**From:** Aishwarya Reddy  
**Sent:** 22 May 2025 15:02  
**To:** Planning.Responses  
**Subject:** FW: FG/43/25/HH, 9 Sea Drive  
**Attachments:** 9 SEA DRIVE-147\_106\_revA.pdf

**Subject:** RE: FG/43/25/HH, 9 Sea Drive

Drawing Title: GATE & WALL AS PROPOSED

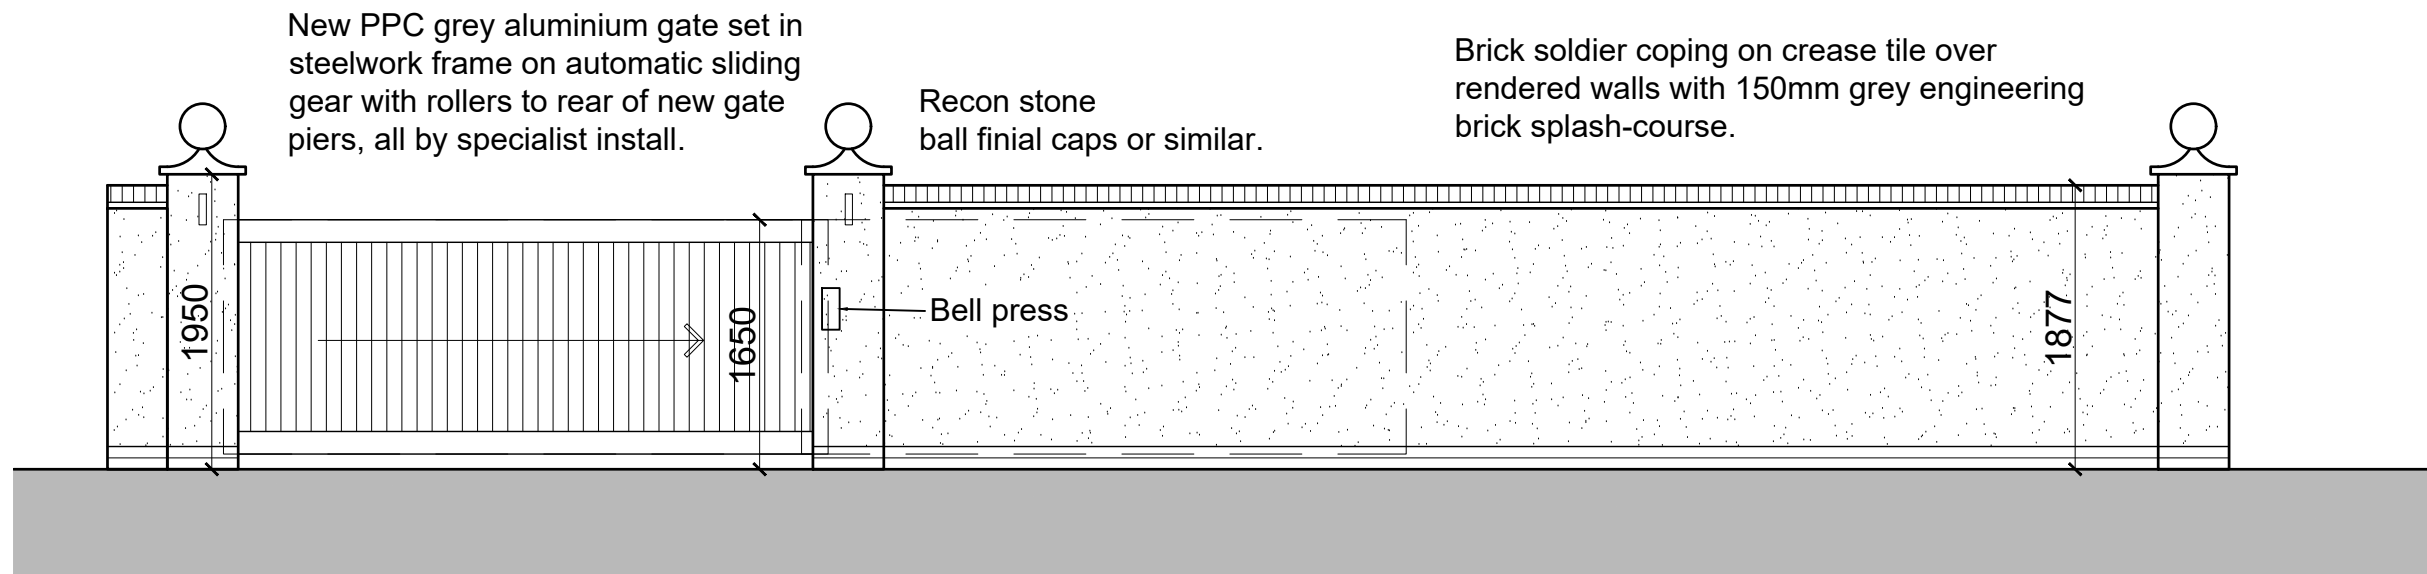
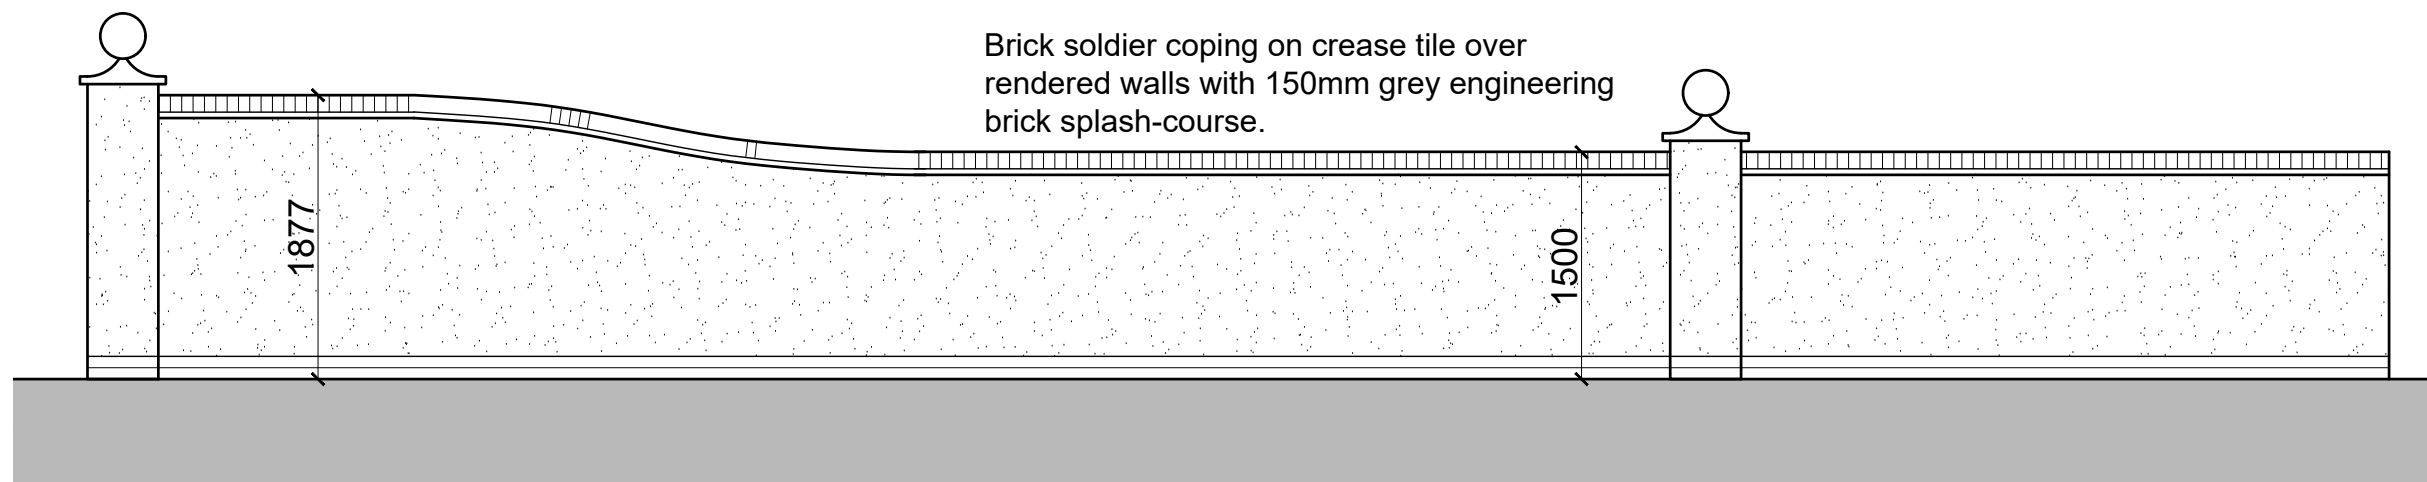
The proposed boundary wall and front gate appear out of character within this street scene. As it stands, the front gate and boundary wall will need to be removed from this application.

I have now consulted with my client and we are ok to drop the wall height down to 1.2m if this will be acceptable? I attach the revised drawing for your consideration and I hope approval. It is noted that there are other similar walls in the road. If there is still concern, then we would consider removal.

If a lower wall and gate was proposed say 1.2m but of same style, would that be acceptable? i.e akin to No. 1 Sea Drive
